RE: M-51 Industrial– Response to City Comments

Please refer to our responses below which address all review comments received from the City of Marysville on September 1, 2023, regarding the M-51 Industrial submittal package. You will find the markup comments listed in the order that they were written followed by our response in *italics*.

EXC. 2 22849
OTTO LINK
APN 31052700201000
COPART OF WASHINGTON INC.

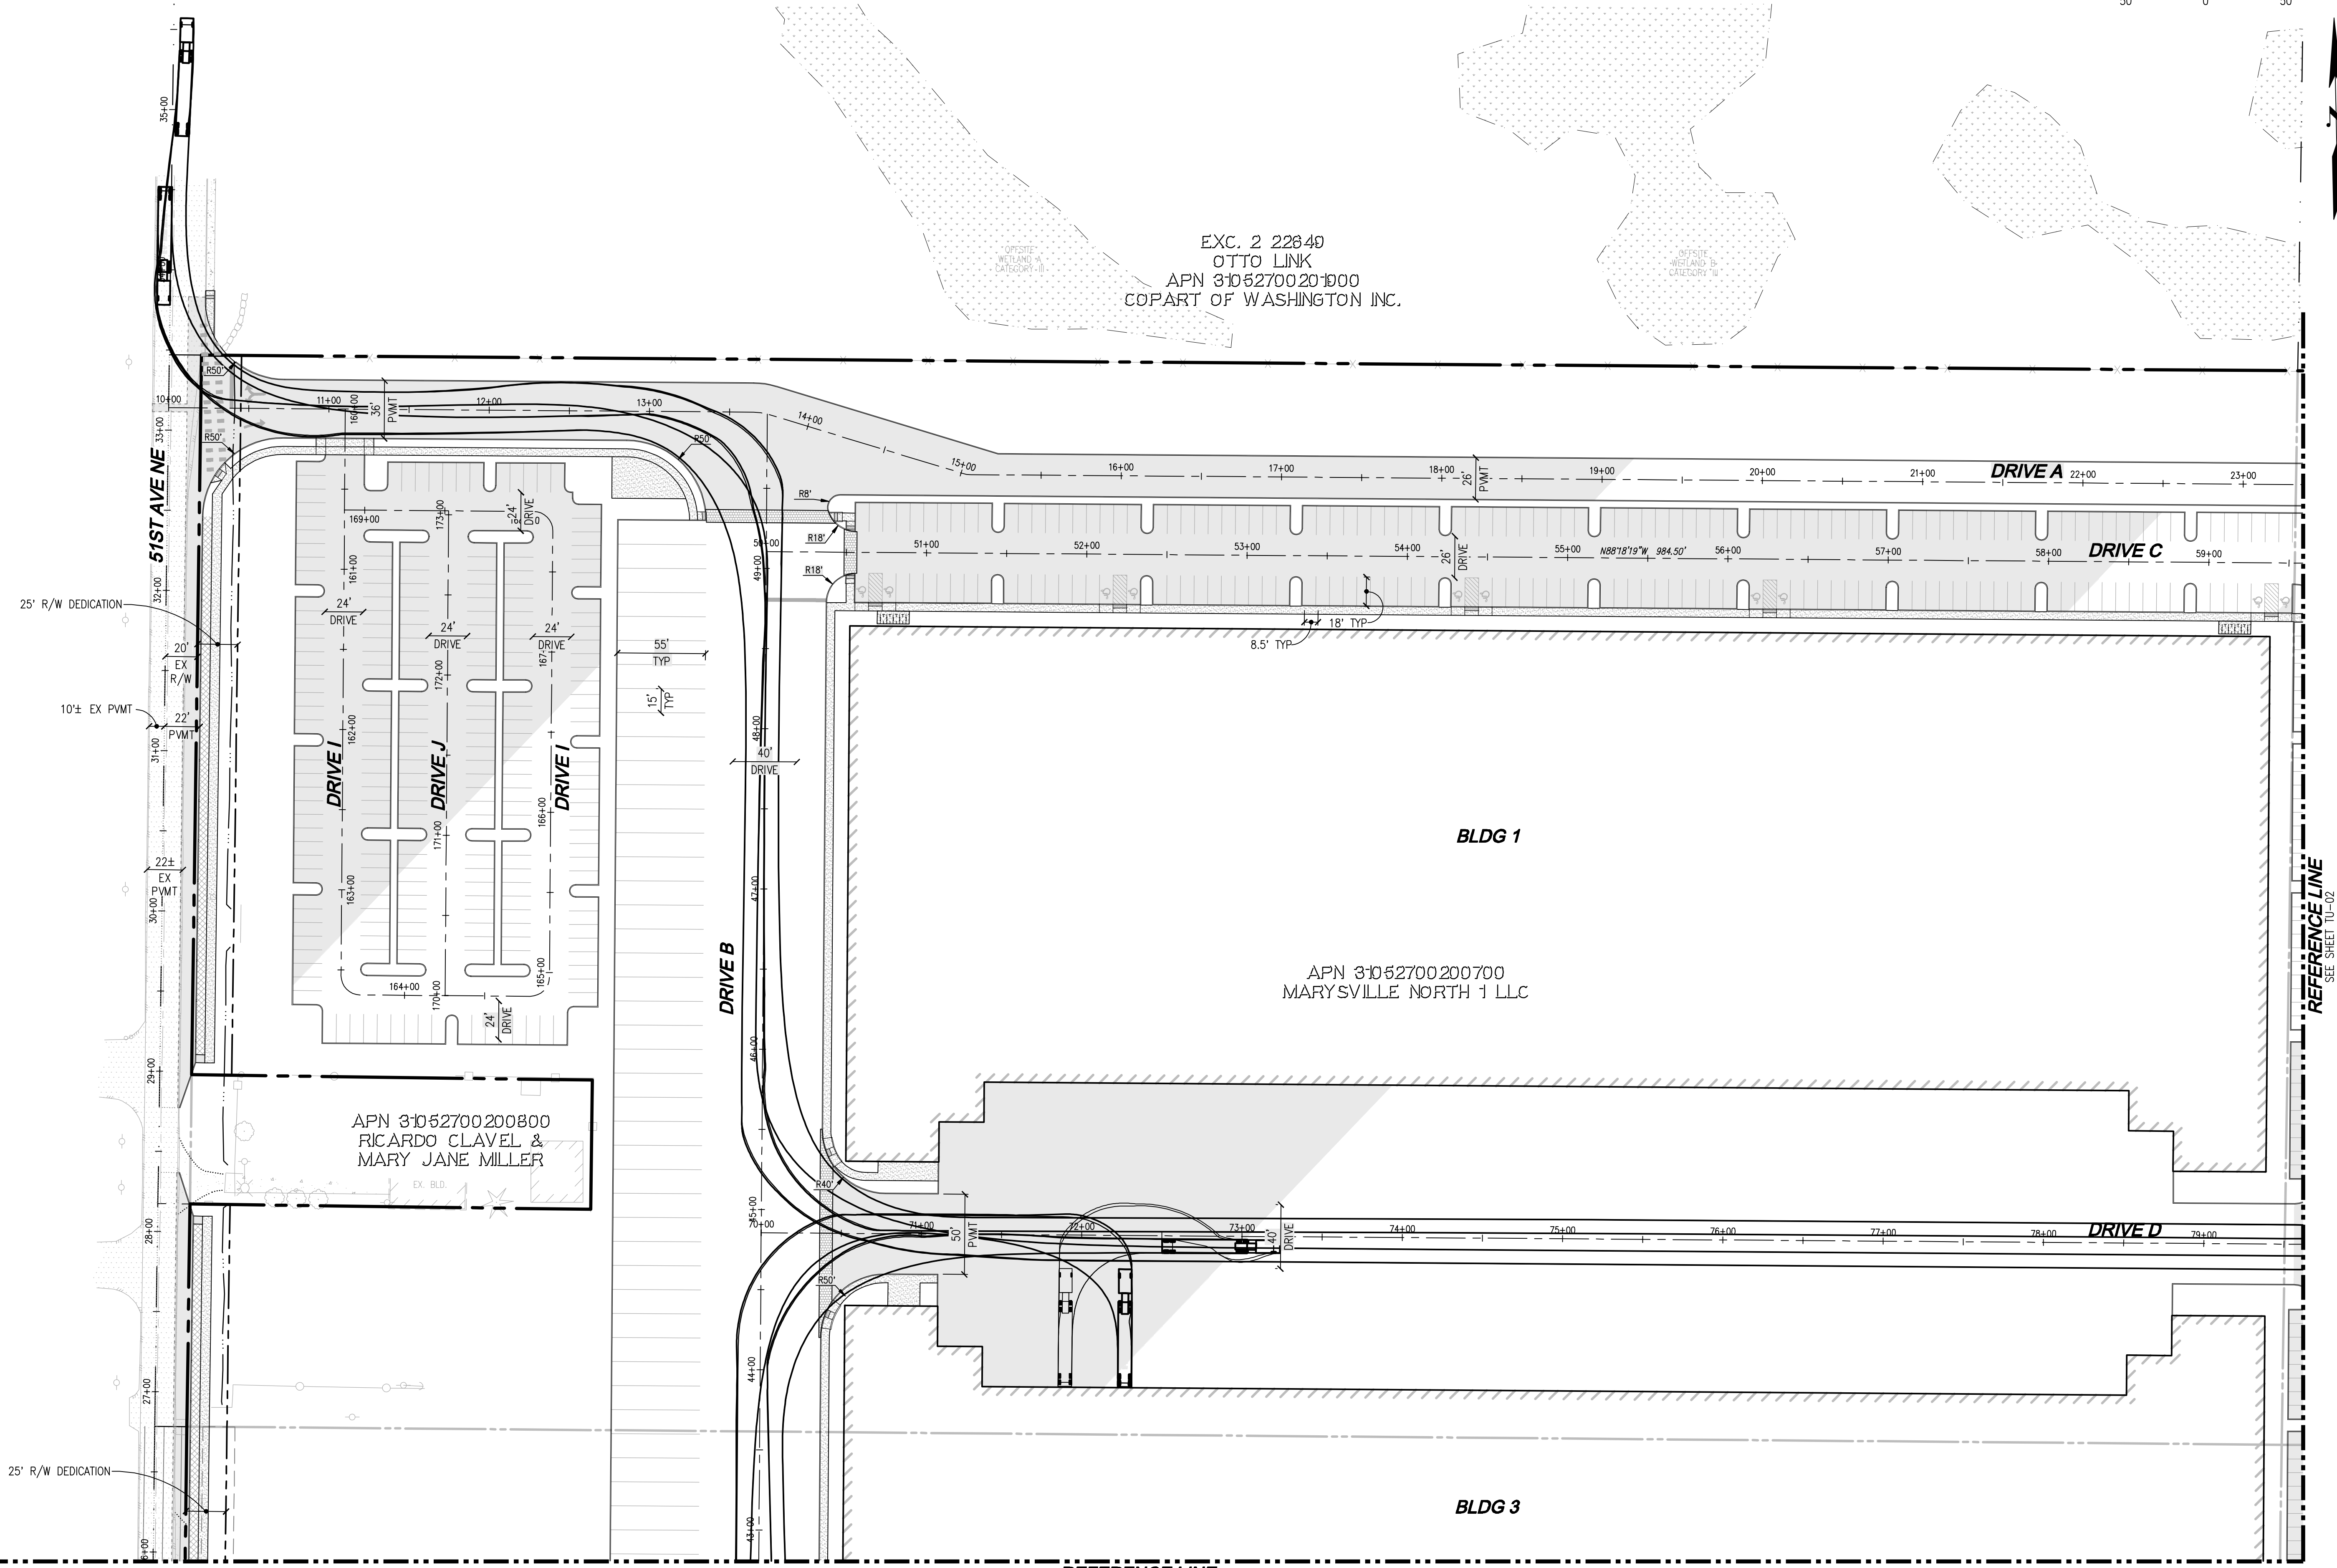
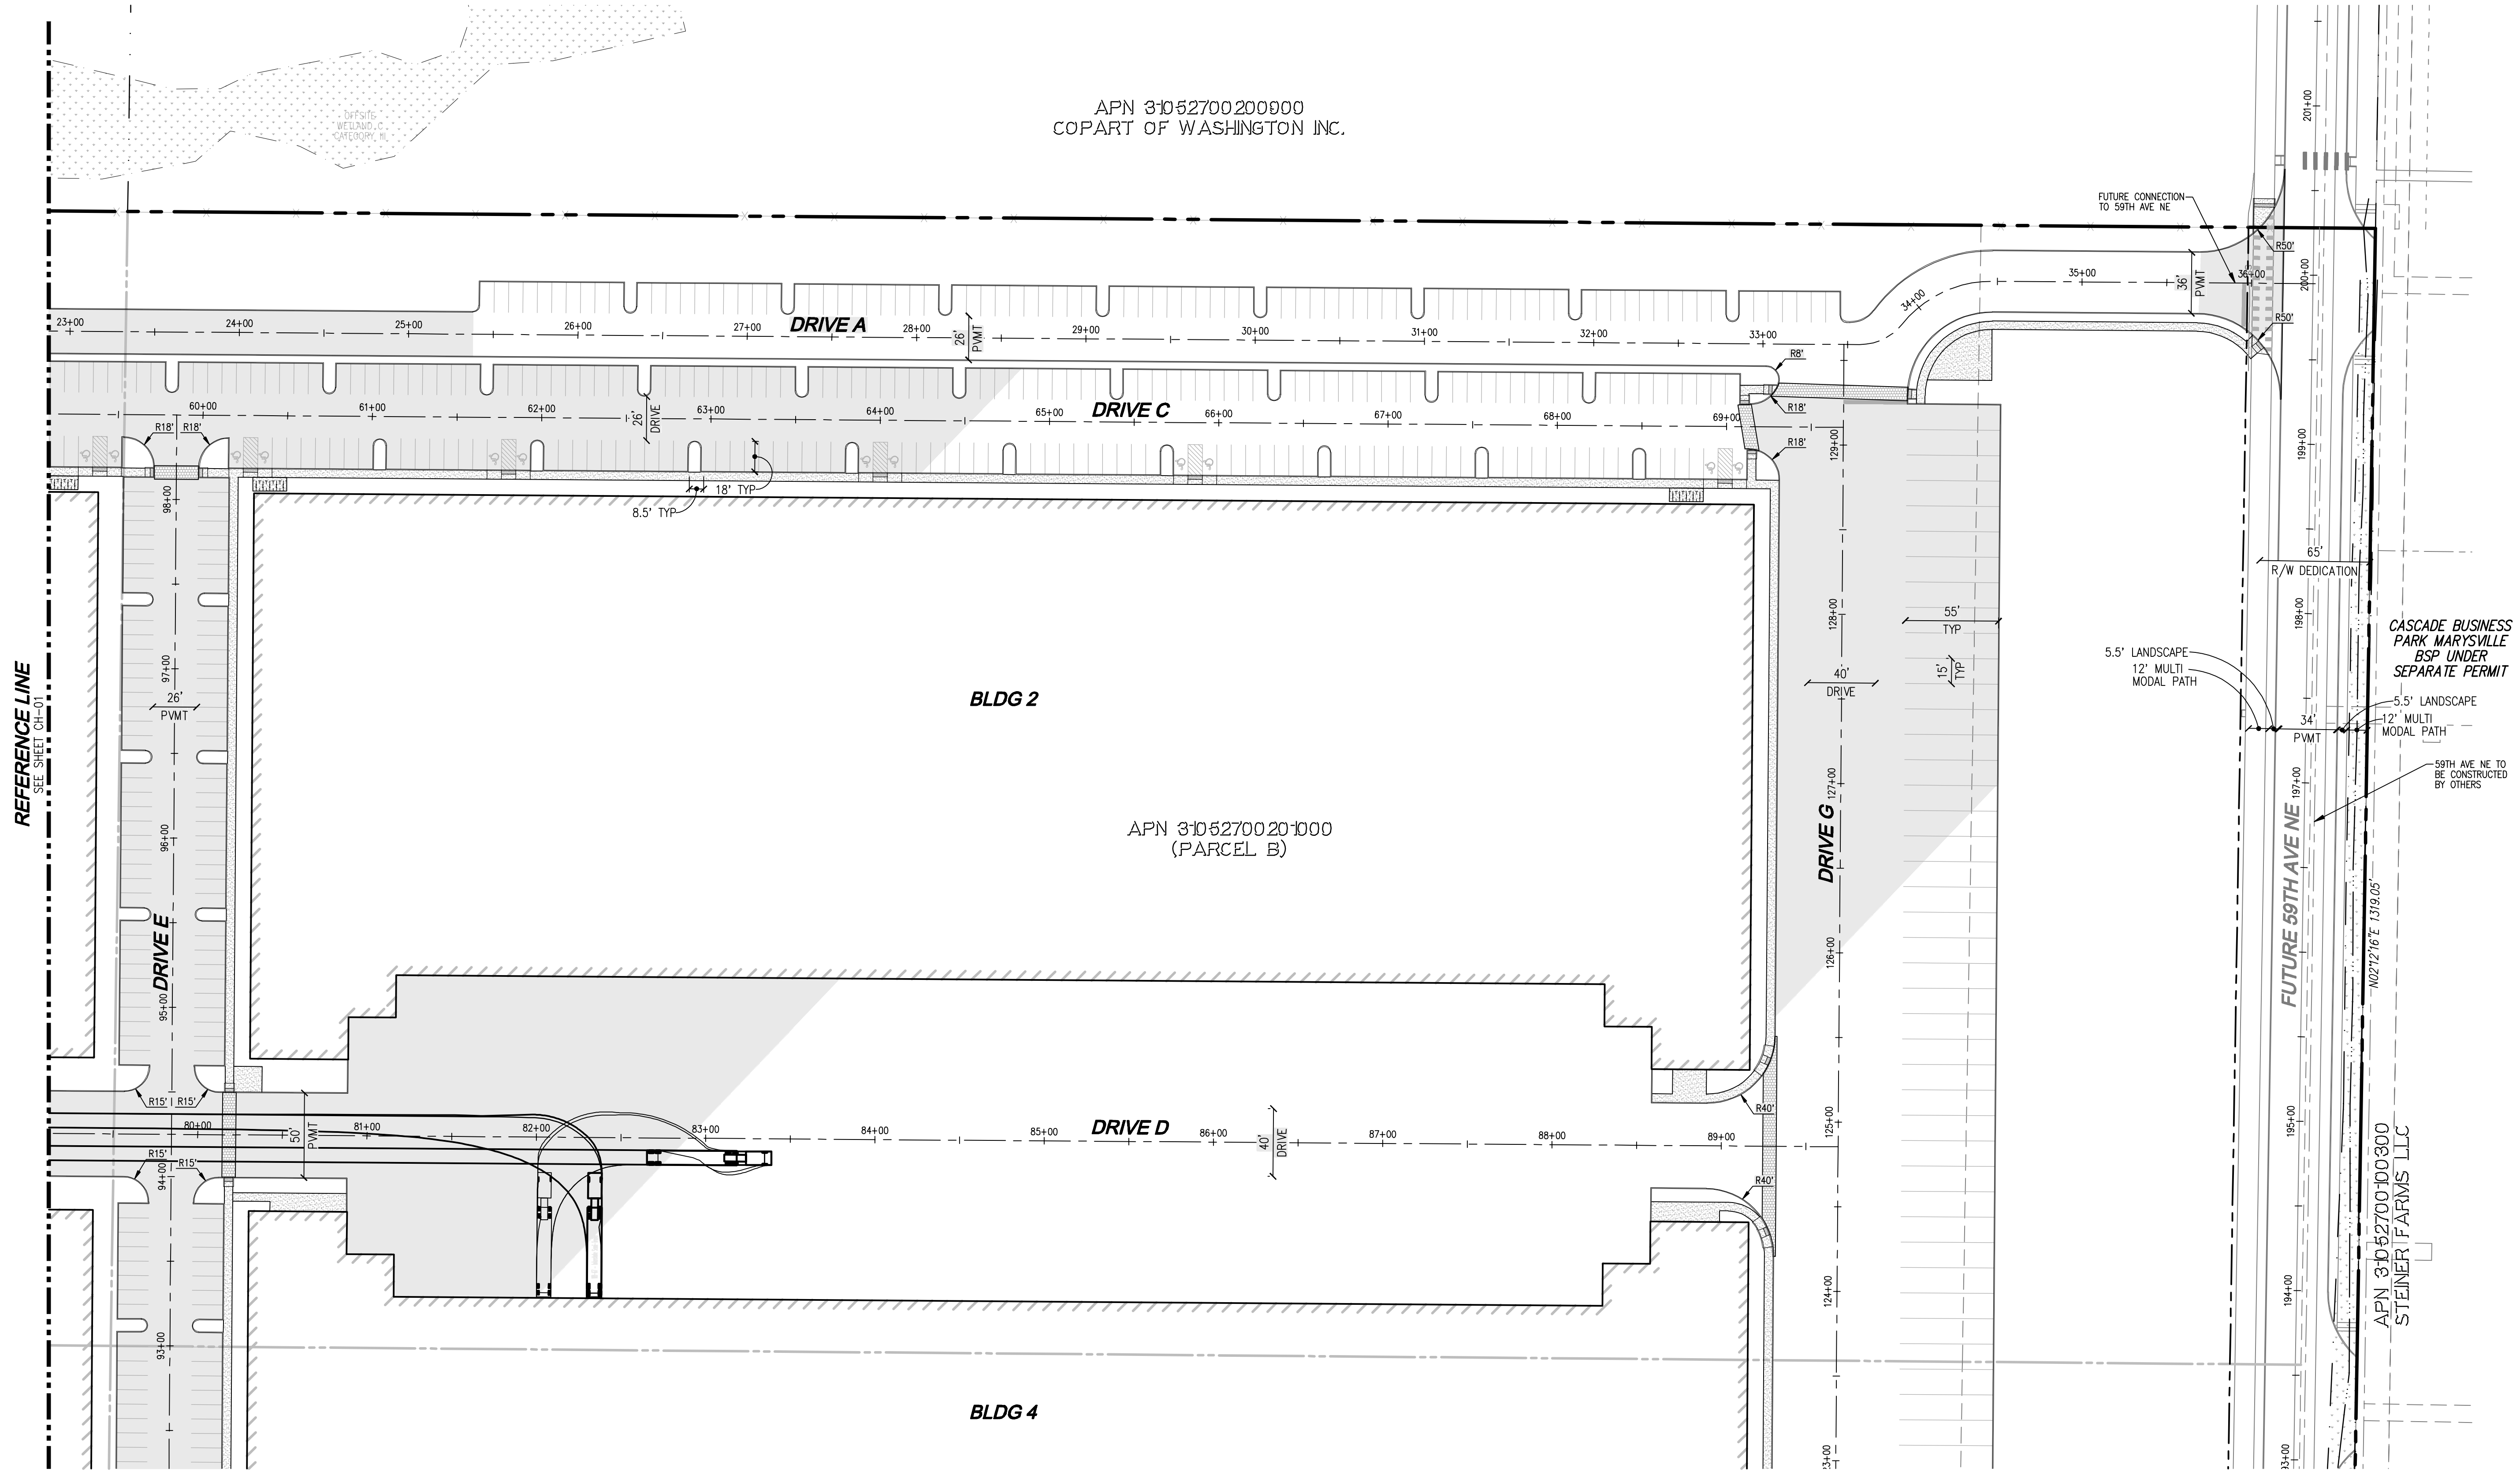
15. Provide auto-turn exhibit demonstrating vehicle and truck traffic can navigate the drive-aisles.

Response: Added Auto-turn diagrams as noted.
